KIRKLEES METROPOLITAN COUNCIL INVESTMENT & REGENERATION SERVICE

Reference No:	2025/44/92614/E
Site Address:	Dixon Hall And Co Ltd, Grafton Street, Batley, WF17 6AR
Description:	Discharge of details reserved by conditions 4 (noise), 10 (delivery management plan) on previous permission 2025/91841 for variation of condition 2 (plans and specifications) on previous permission 2024/93177 for change of use from office building to residential apartments and associated alterations
Recommending Officer:	Edward Cheseldine

DECISION – DISCHARGE OF CONDITION – SPLIT DECISION

2025/92614 - Dixon Hall And Co Ltd, Grafton Street, Batley, WF17 6AR

Figure 2 – Measurement Locations and Site Surroundings

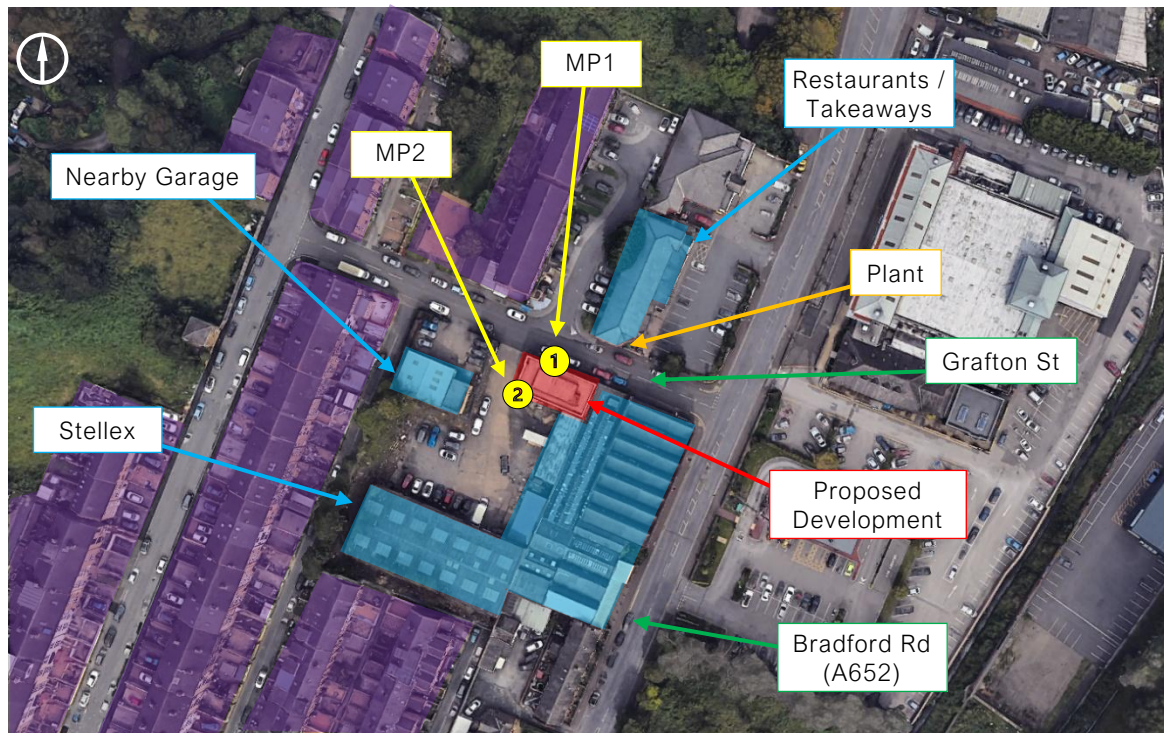
An environmental noise survey was undertaken between the 7th and the 9th of May 2025 from two measurement positions (MPs) as shown in figure 2 and a

Figure 3 – Façade Allocation – All Floors

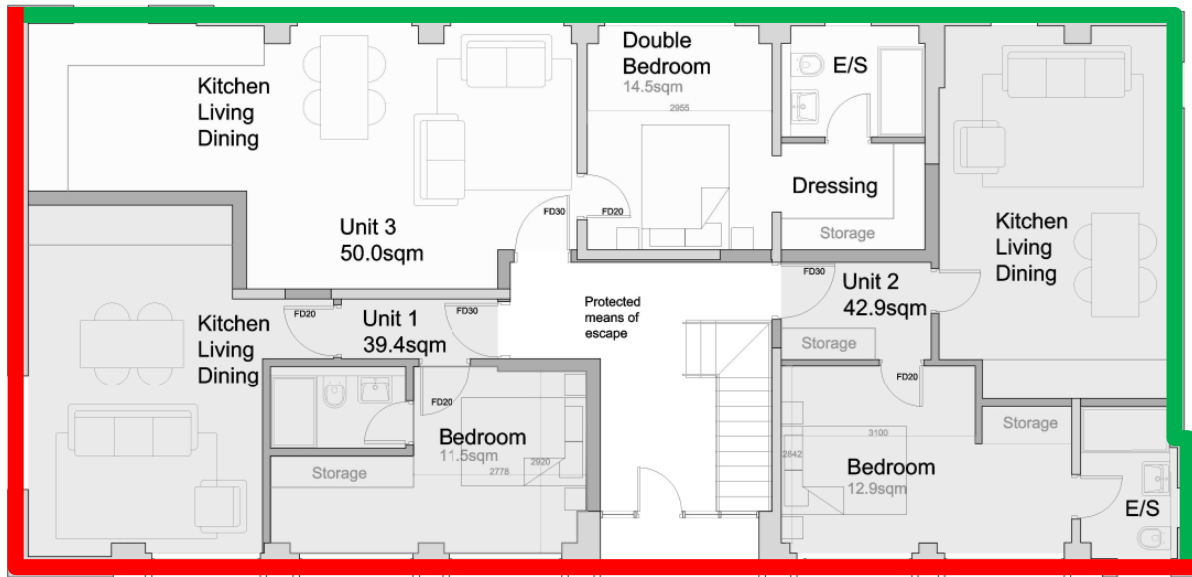
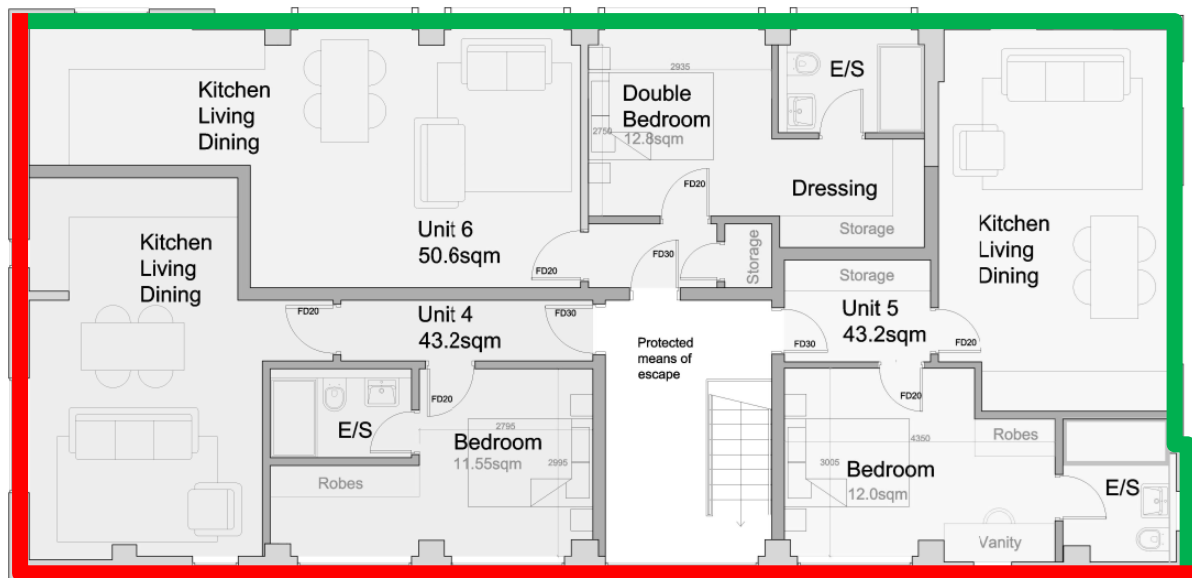
Aside from traffic noise originating from the adjacent road network, no notable noise emissions were detected at the front of the site. In order to meet with the internal requirements of BS8233, glazing and ventilation is specified dependent on the façade and this is shown in colour coded format in figure 3. The specification is given in table 4.
